**KIRKLEES METROPOLITAN COUNCIL
INVESTMENT & REGENERATION SERVICE**

DELEGATED DECISION TO DETERMINE PLANNING APPLICATIONS

Reference No:	2025/62/91229/W
Site Address:	29, Birklands Road, Cowcliffe, Huddersfield, HD2 2PF
Description:	Erection of single storey rear extension and dormer
Recommending Officer:	Jennifer Booth

DECISION - REFUSED

Drawing Title:
Proposed Sections & 3D Views

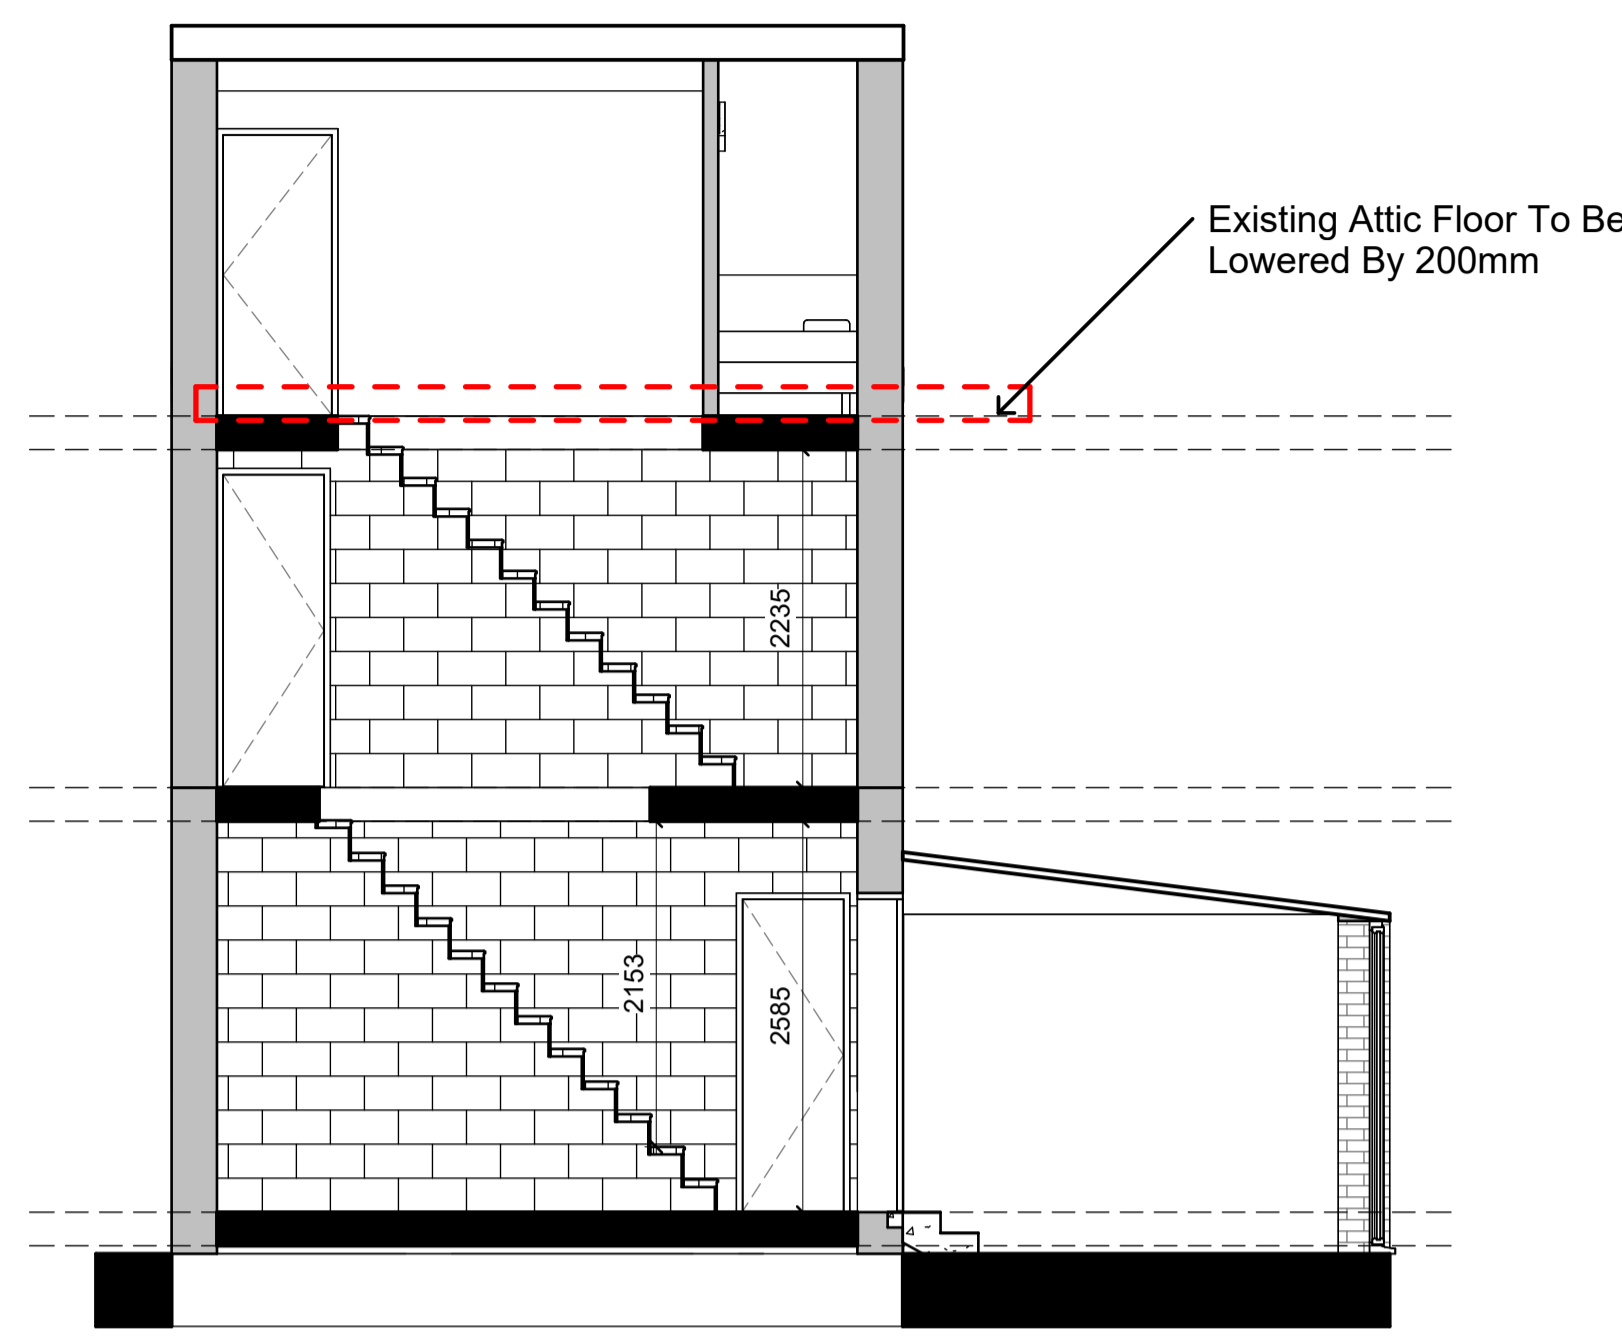
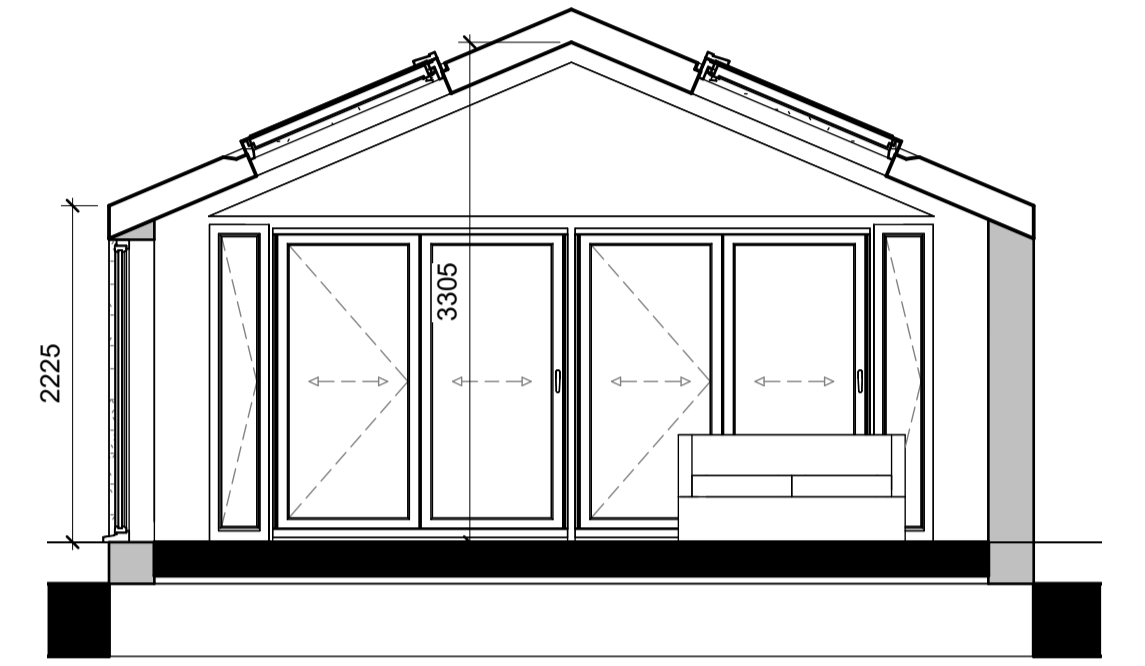
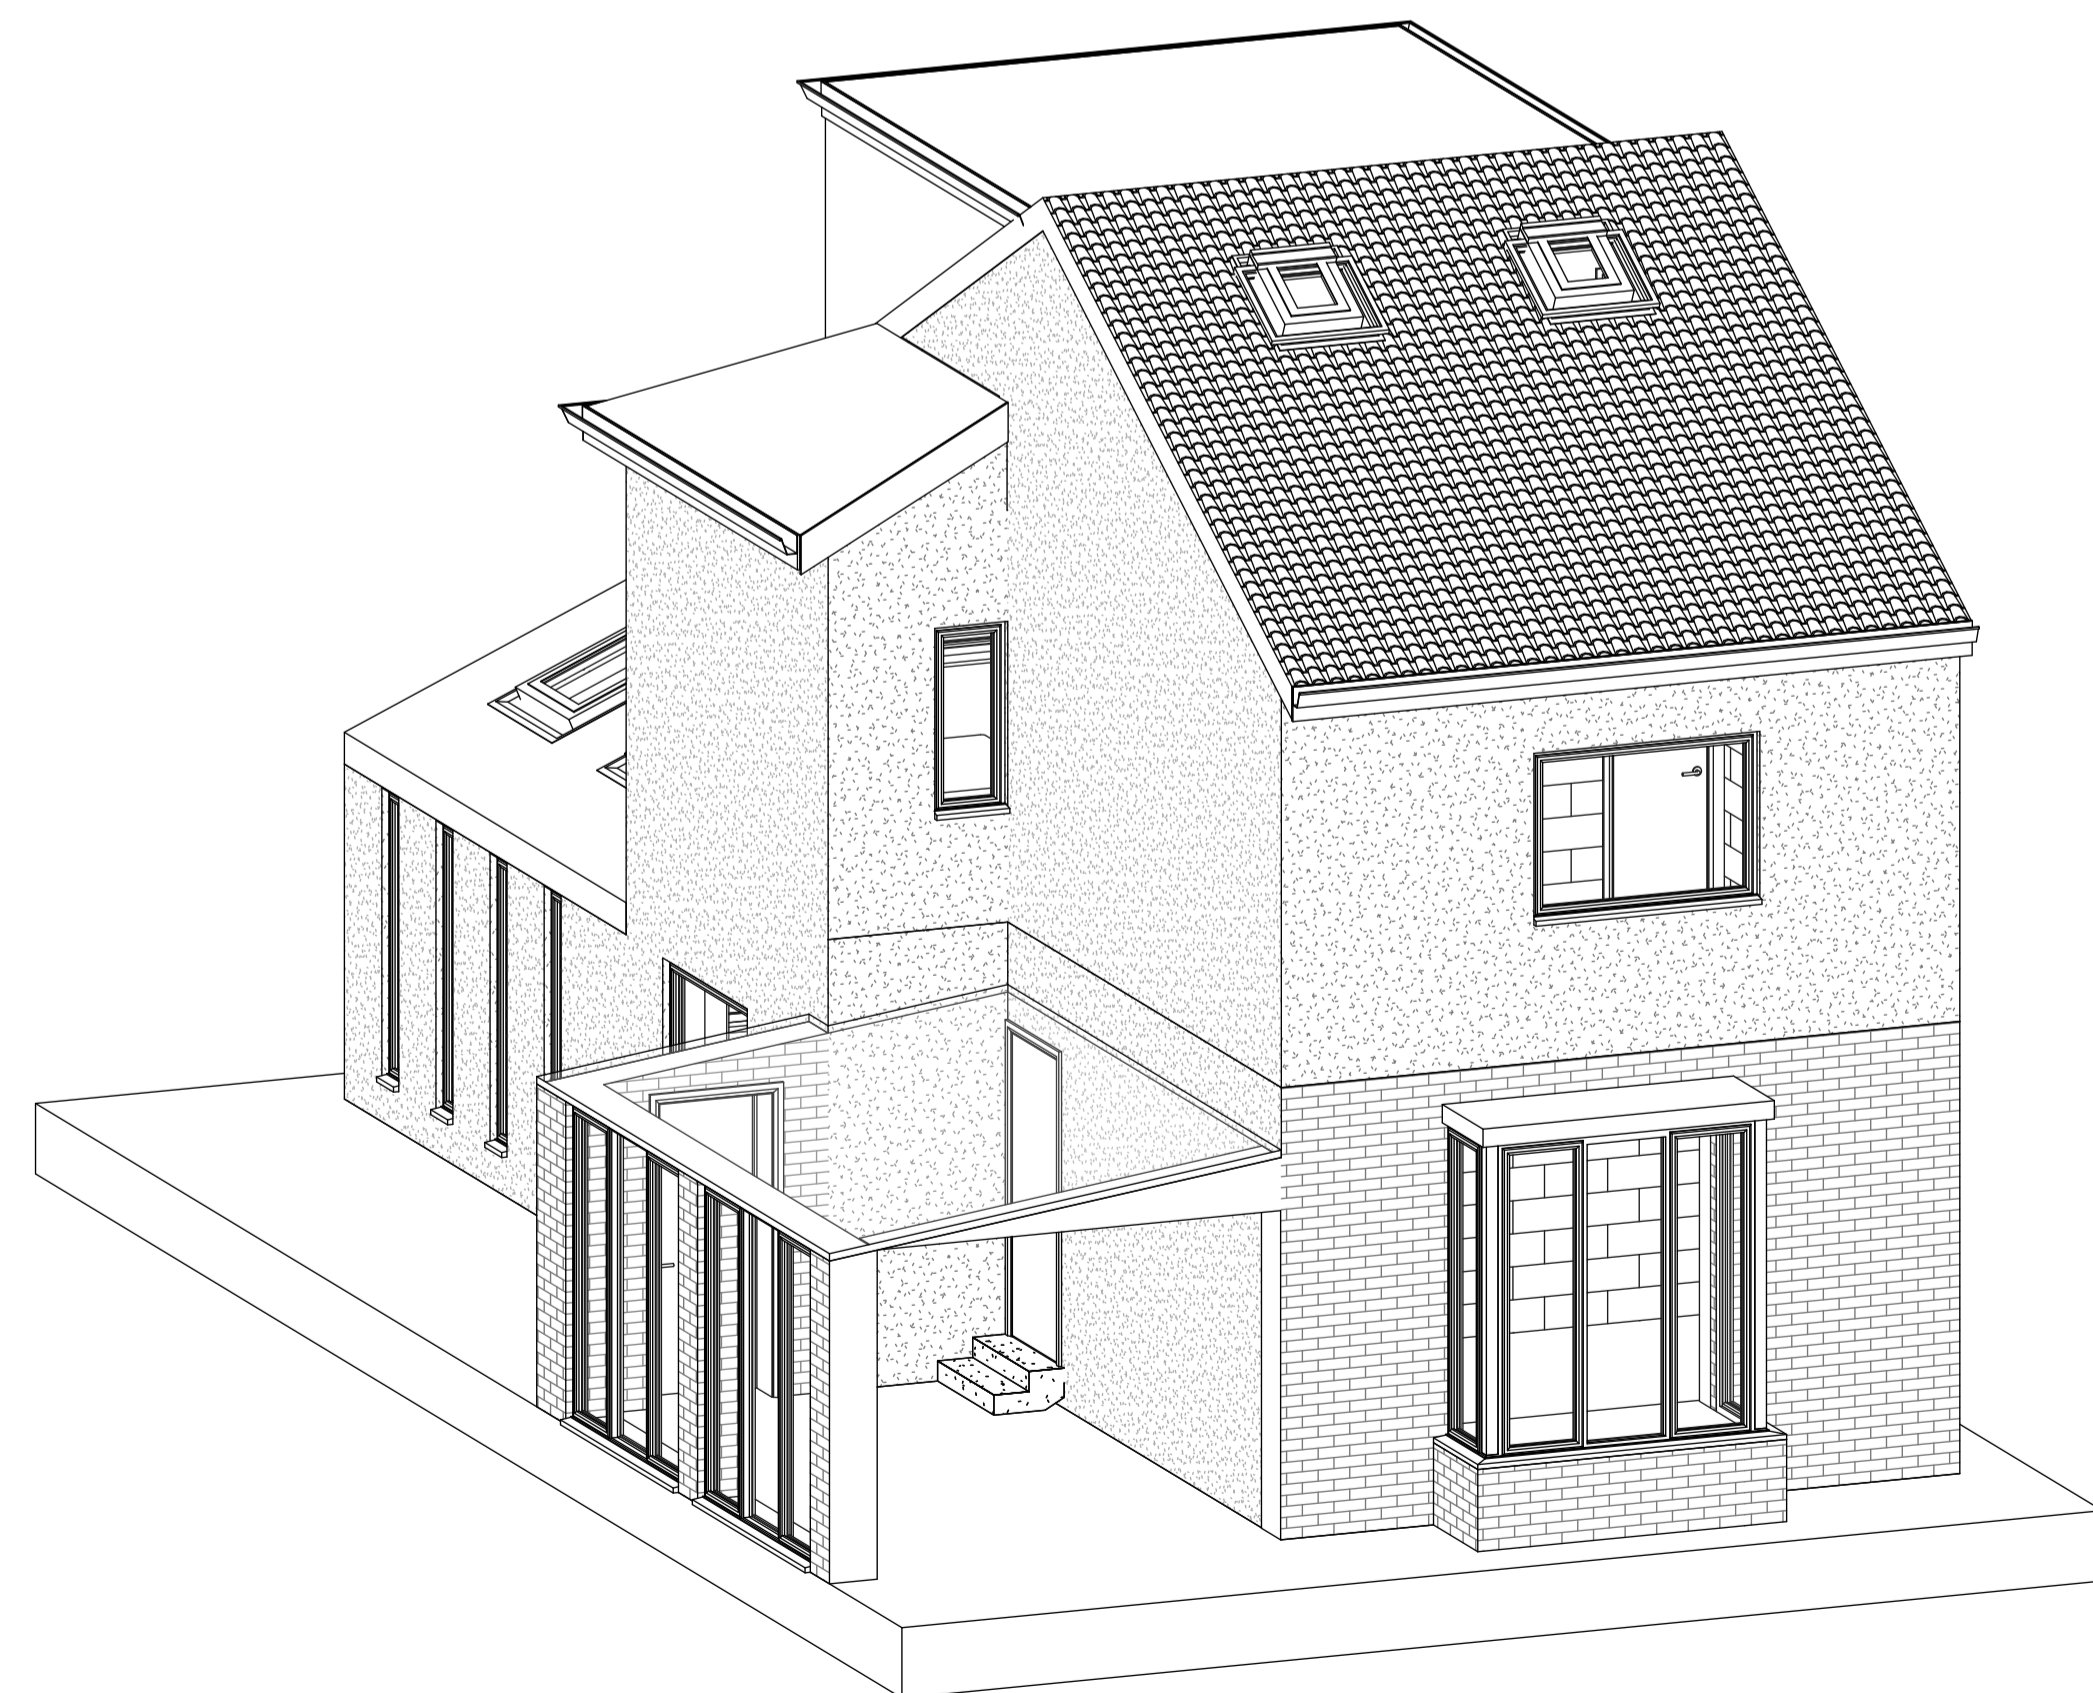
The proposed single-storey rear extension projects further than would typically be supported. The generous size of the rear garden allows the extension to be accommodated without resulting in overdevelopment to the

site per se. However, the projection is significant and the scale and mass competes with the host building detracting from the modest semi-detached property.

The use of matching materials ensures the extension remains in keeping with the character and appearance of the host property, however the projection, scale and mass would detract from the host building and character of the area.

The proposed extension has been constructed on the boundary with 31 Birklands Road to the north-west and projects 5 metres from the rear elevation. Due to its scale and siting, the development is considered to have an overbearing impact on the adjoining property, with the building also affecting the rear elevation and garden area during morning hours through overshadowing. While no windows are proposed in the side elevation facing No. 31, the rear-facing windows would overlook the applicant's own garden, limiting concerns regarding direct overlooking. Nonetheless, the overall impact on residential amenity is unacceptable due to the overbearing and overshadowing effects.

The proposed rear extension, constructed on the shared boundary with 31 Birklands Road and projecting 5 metres from the rear elevation, results in an unacceptable overbearing impact and causes overshadowing of the neighbouring property's conservatory, dining room window and garden during morning hours. To permit the proposals would be contrary to Policy LP24 of the Kirklees Local Plan, KDP5 & KDP6 of the House Extensions & Alterations SPD and Chapter 12 of the National Planning Policy Framework.
